Town & Country Planning Act 1990 (as amended)
Town and Country Planning (Development Management Procedure) (England) Order 2015
Approval of details reserved by condition imposed under AL/20/21/PL relating to condition 11-
discharge of flows.

Land At Wings Nursery Lidsey Road Woodgate PO20 3SU

Arun District Council have decided to **REFUSE details reserved by condition for the following reasons:**

Drawing Title Existing Watercourse Alterations General Arrangement and Levels

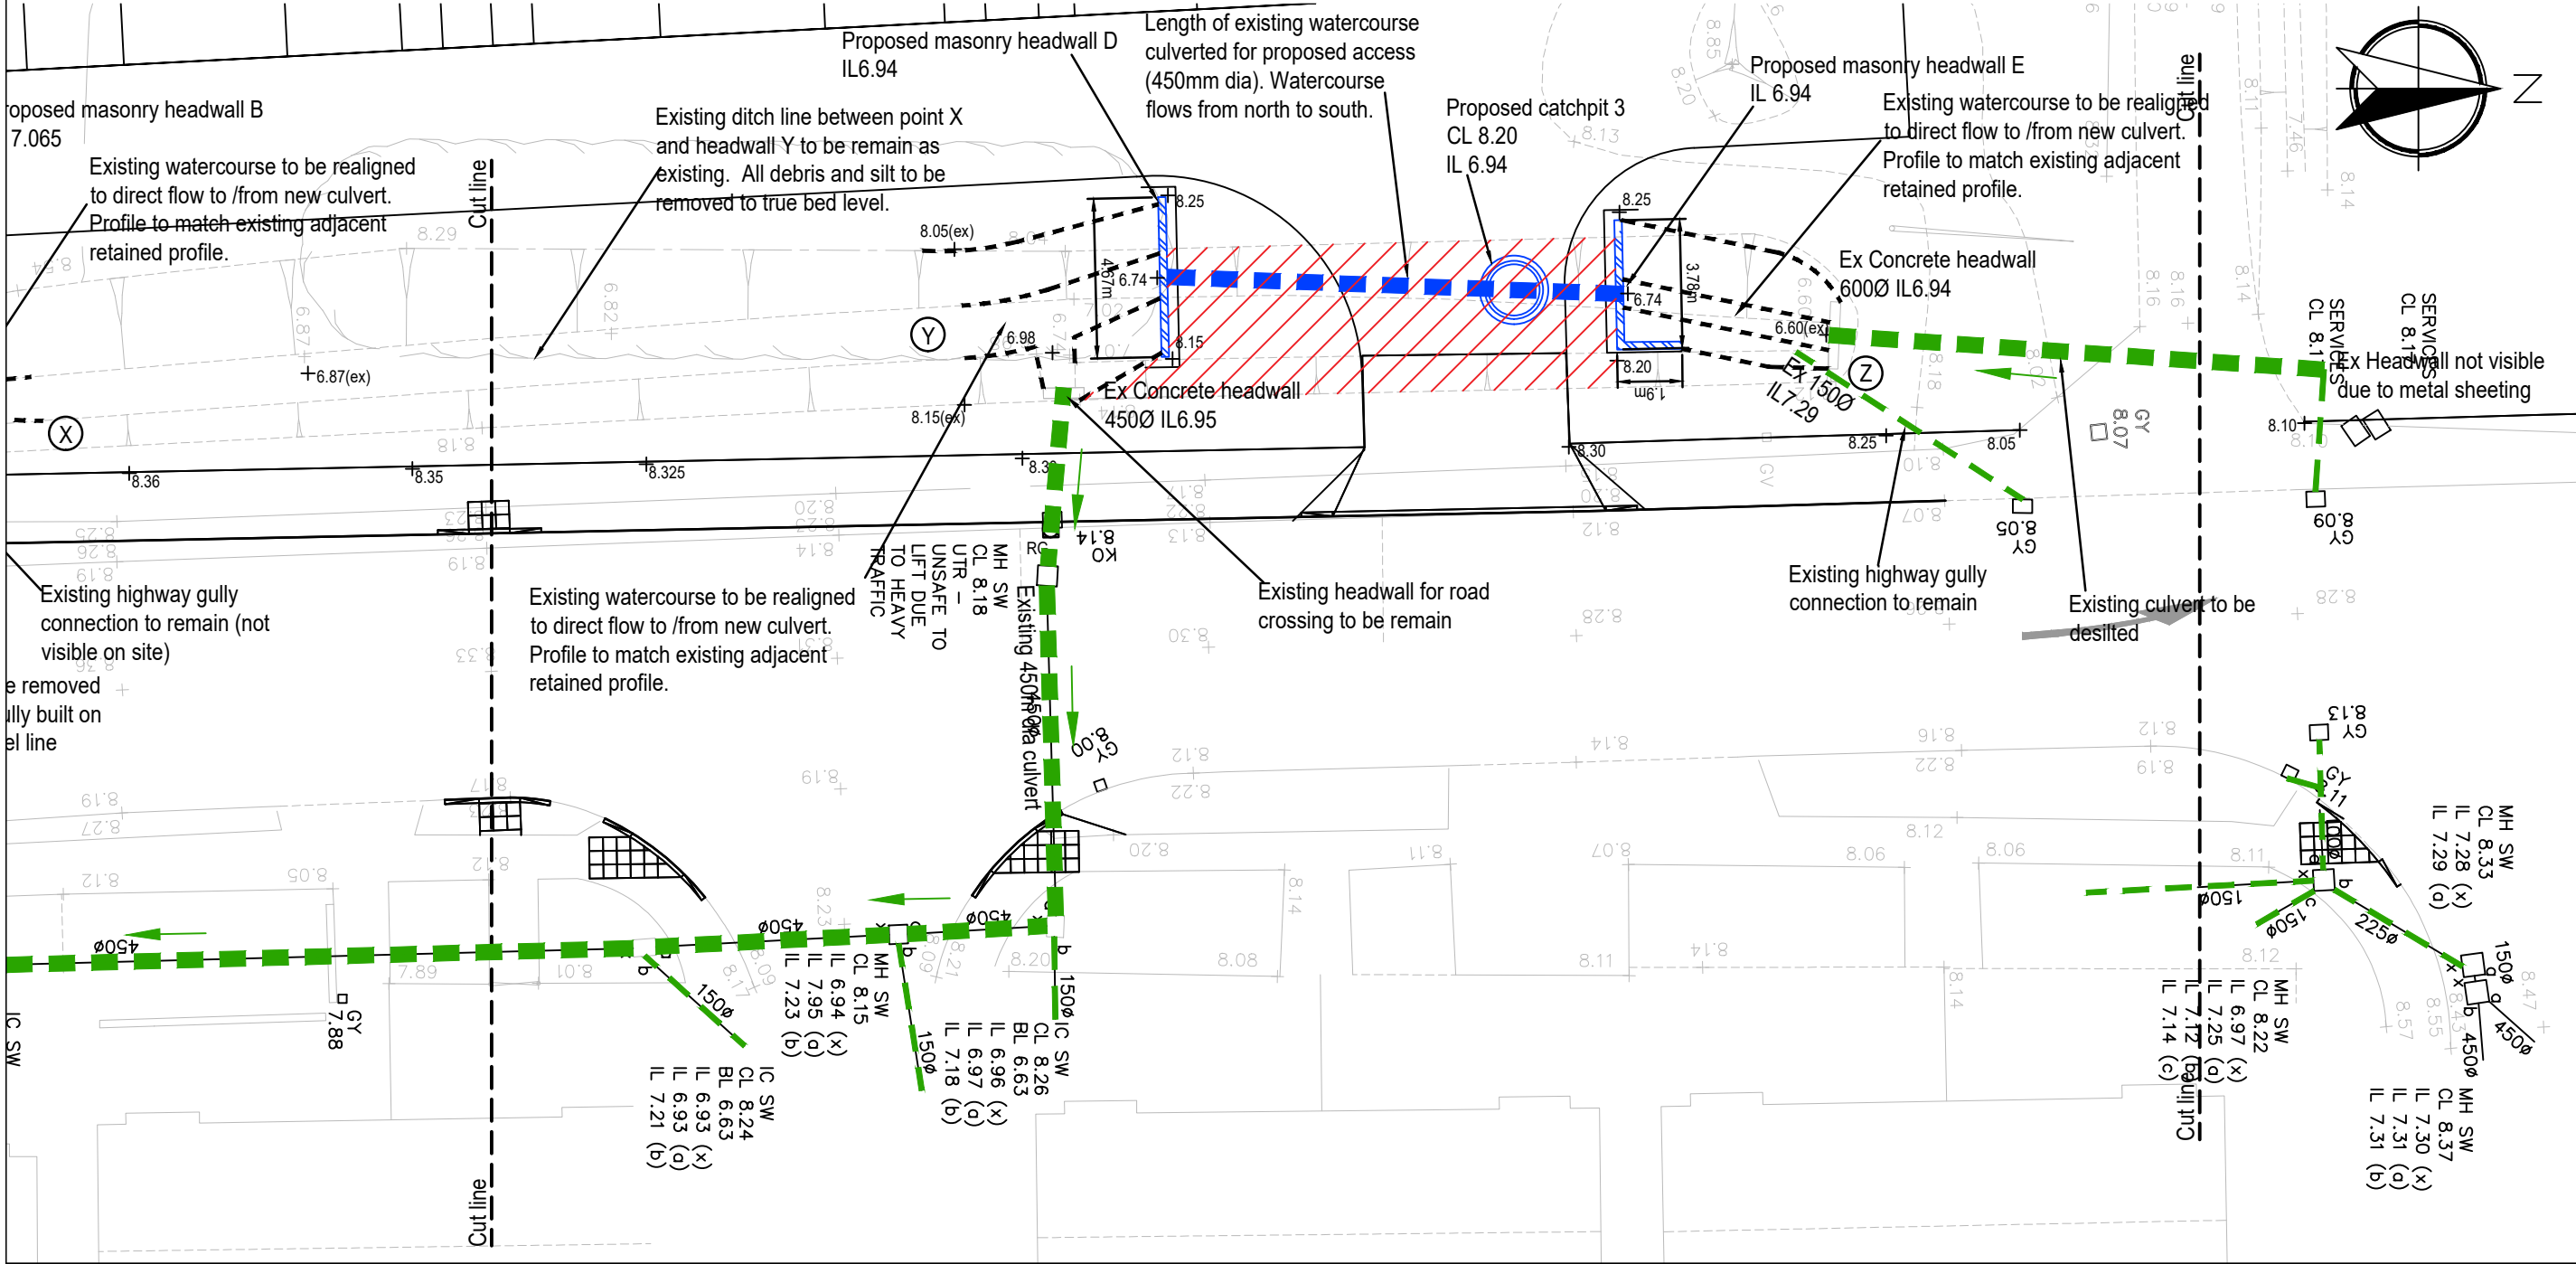
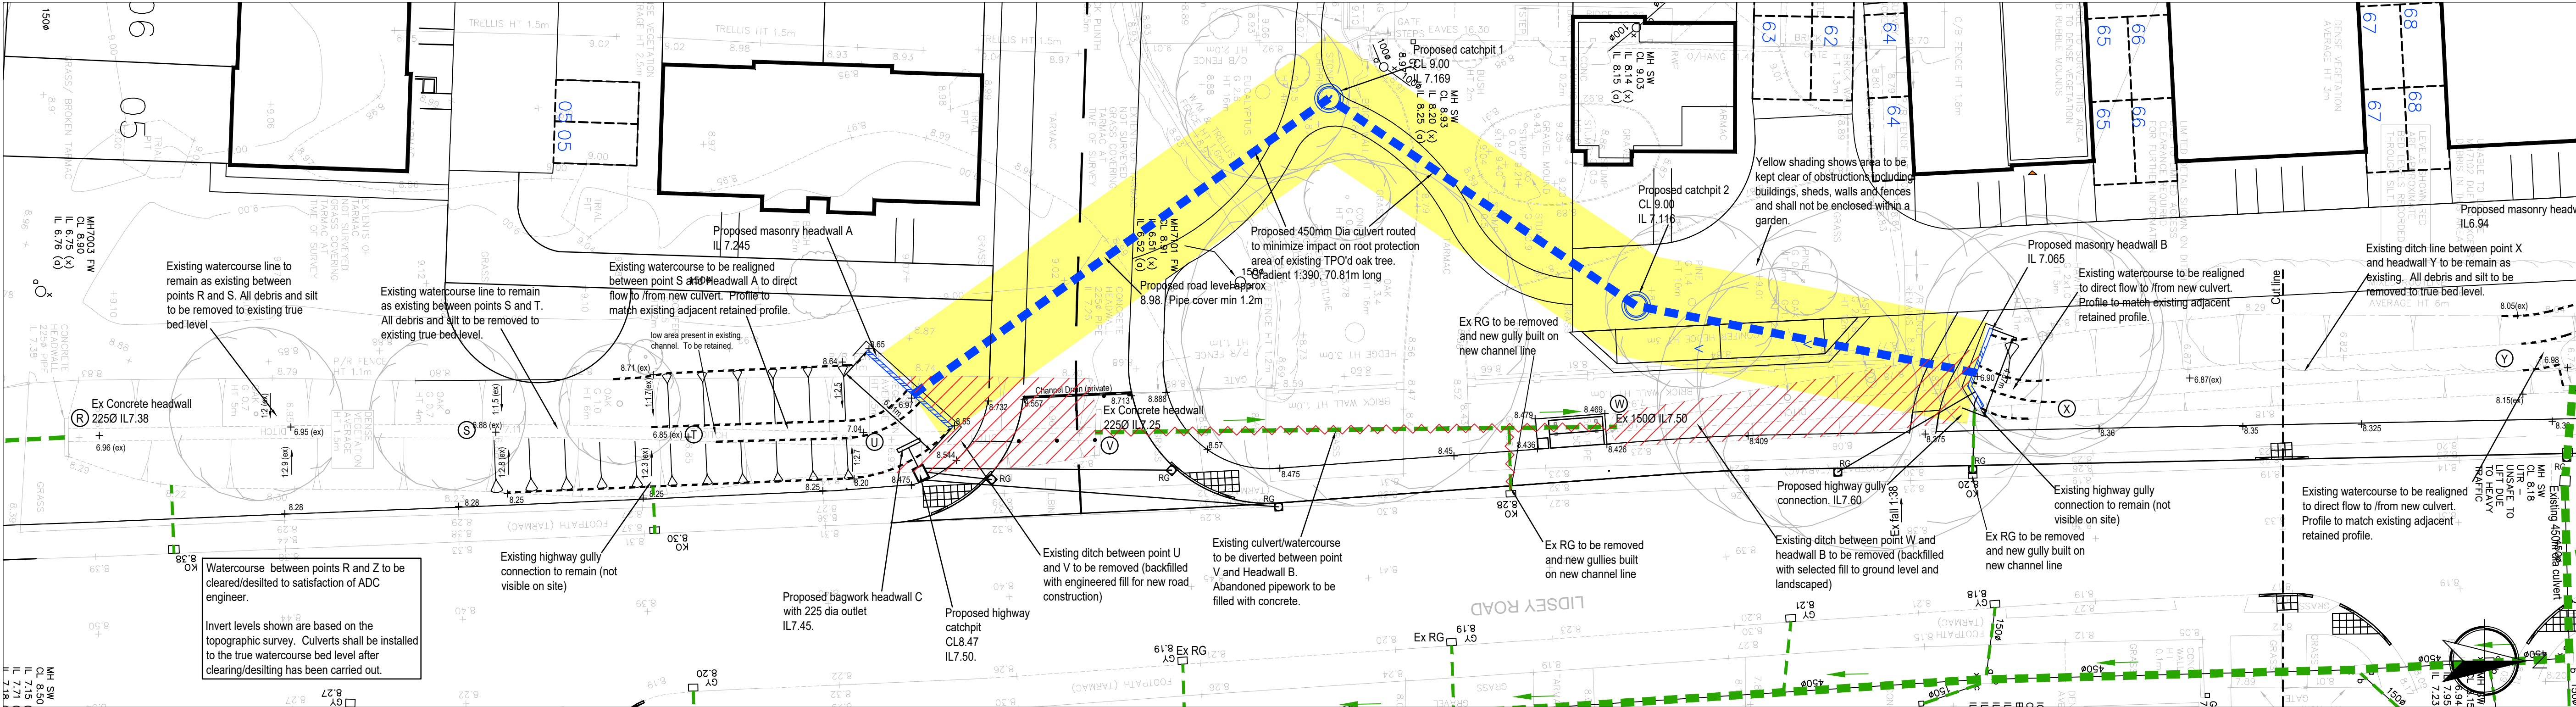
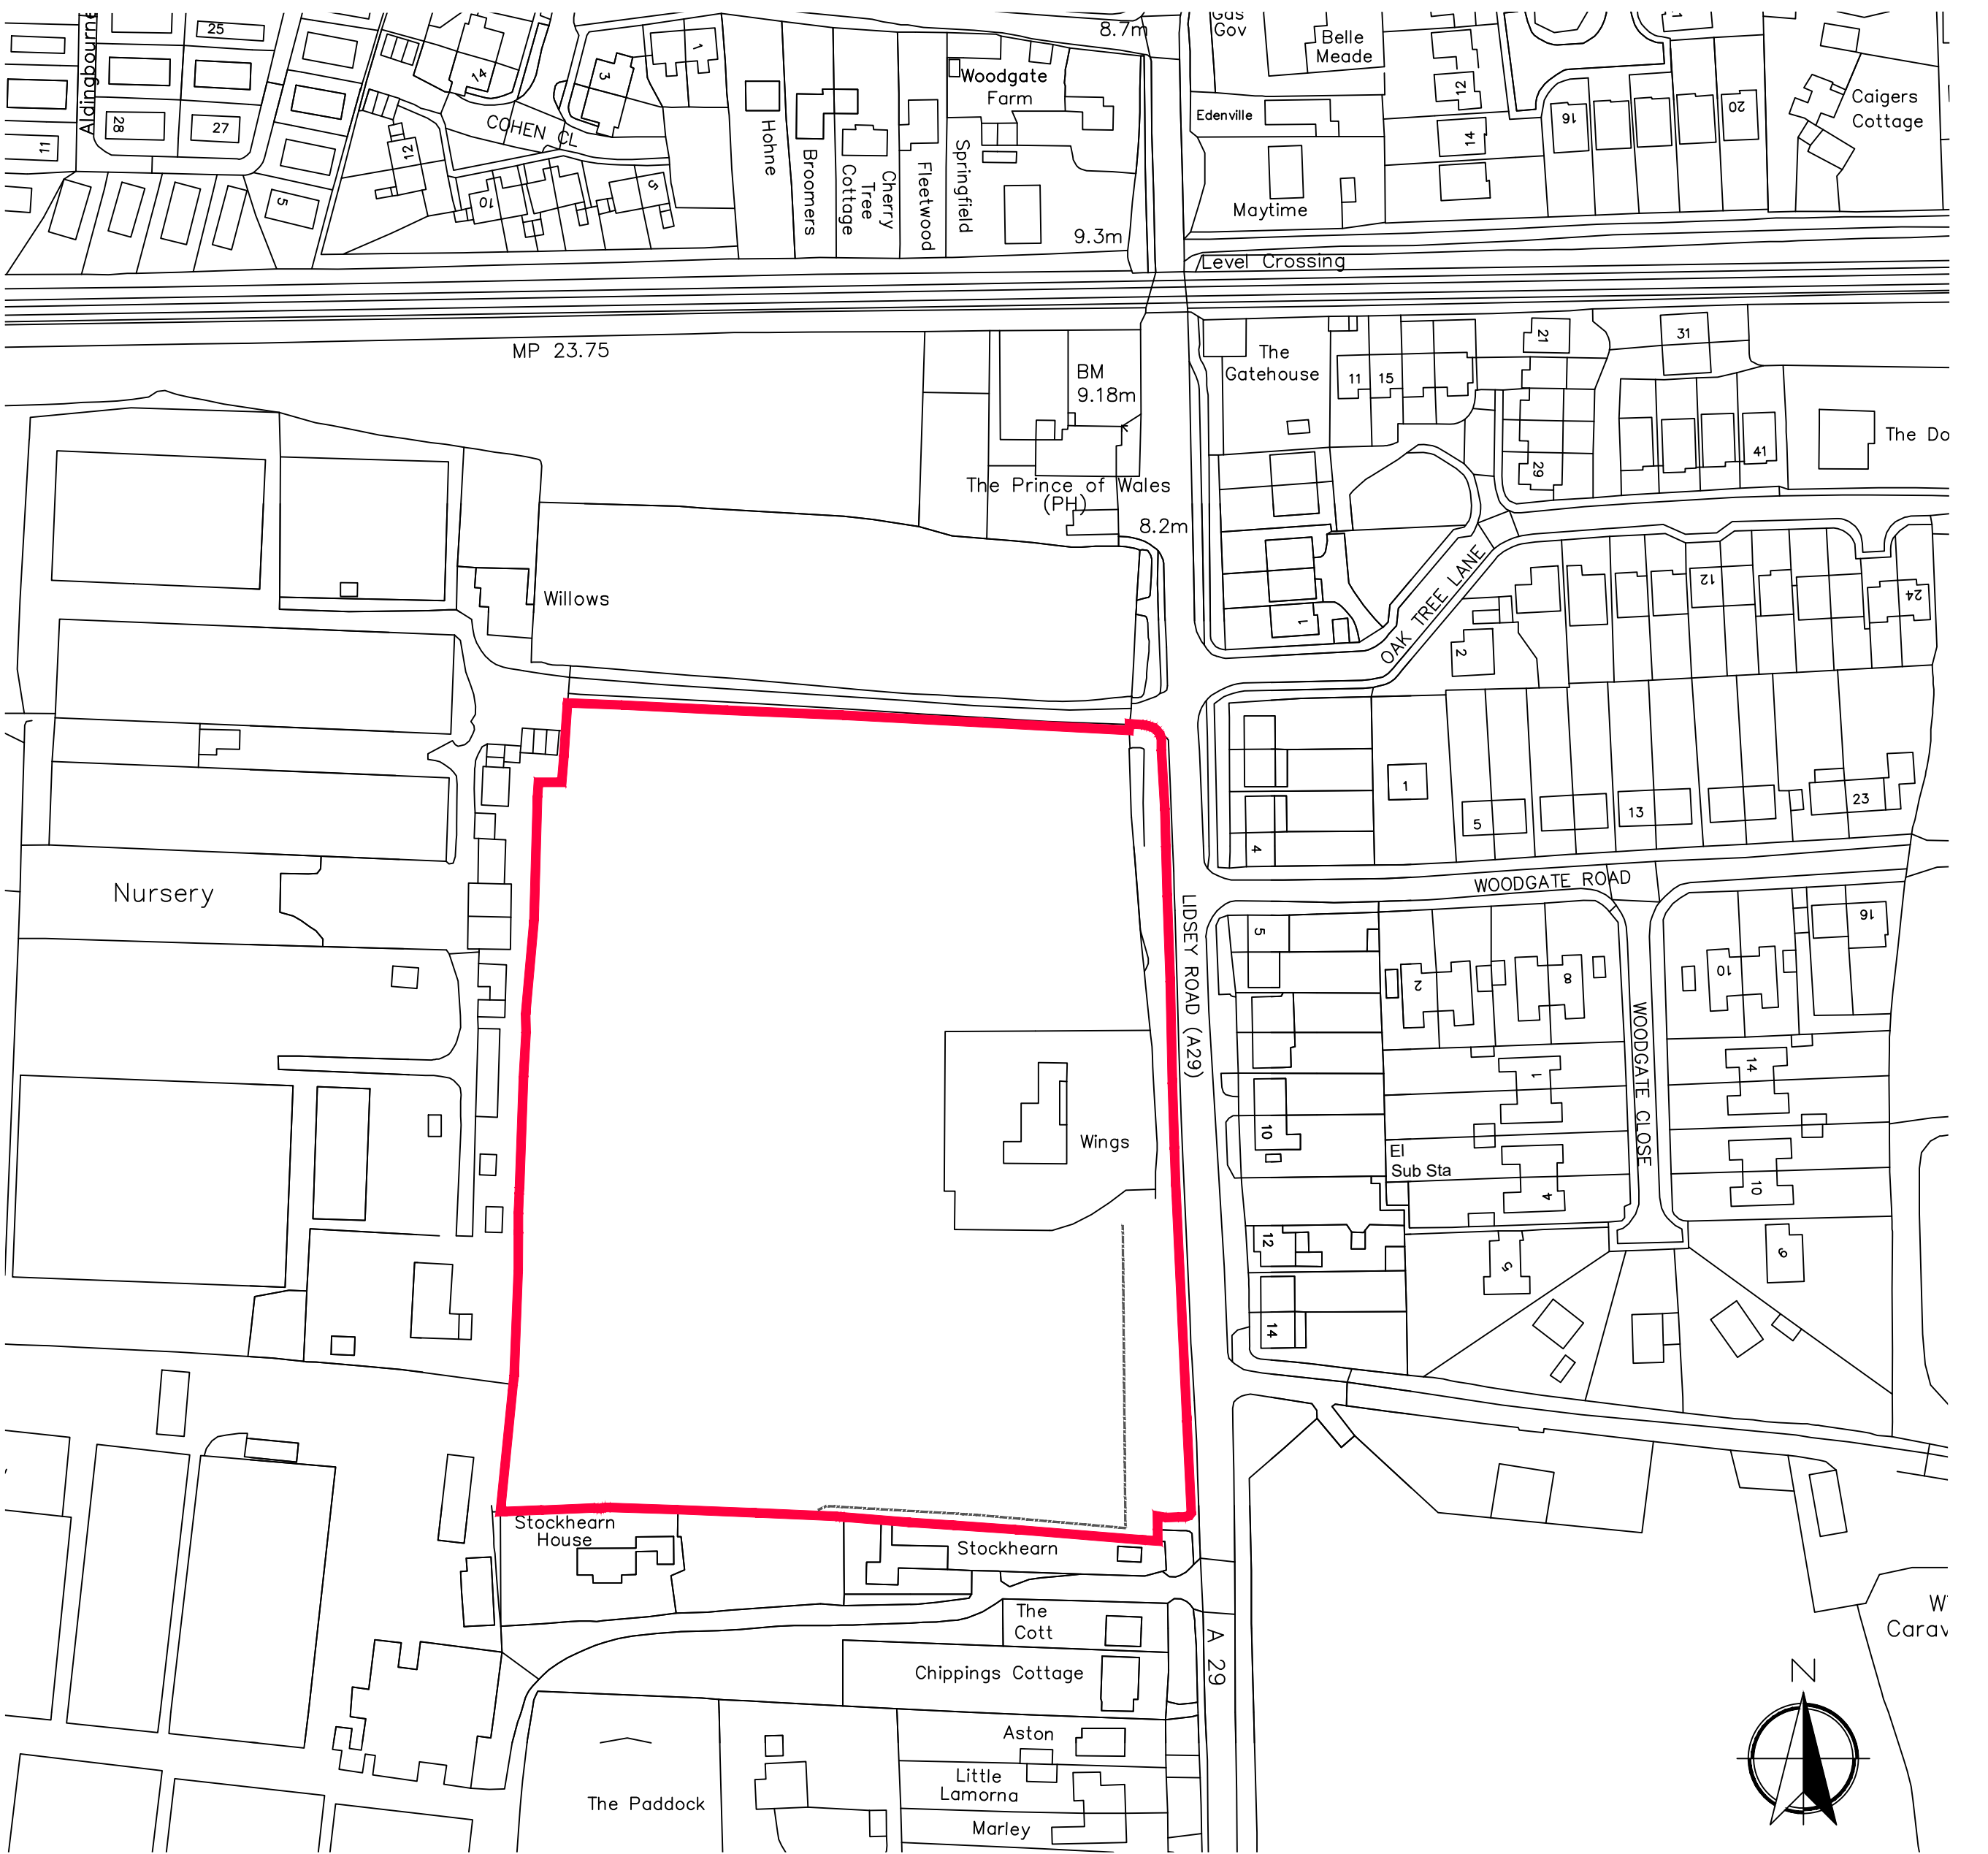
not include consent for the new drainage connections. Please apply for land drainage consent for the two new outfalls, i.e. for the proposed connection to the new culvert and for the proposed headwall further north on the open watercourse. Please supply evidence of consent.

Please also confirm if it has been verified if there is any culvert outlet for the ditch on the western boundary?"
